Application for Outline Planning Permission

Development: Outline planning application (with all matters except access reserved) for the construction of 31 residential units.

Location: Westholme Nursery Toddington Lane Littlehampton BN17 7PP

**Proposed Two Bedroom Flats**

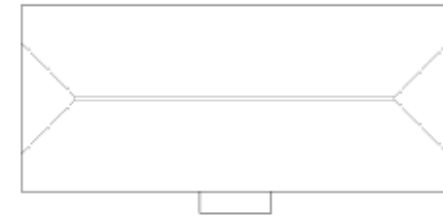
The windows serving the second floor of the affordable flats are different on the proposed elevations and floor plans. There is also an opening shown at first floor over the existing entrance on the floor plans, but only a window on the elevations. Please amend these accordingly and resubmit. You may need to amend your statements that include any of the erroneous plans.
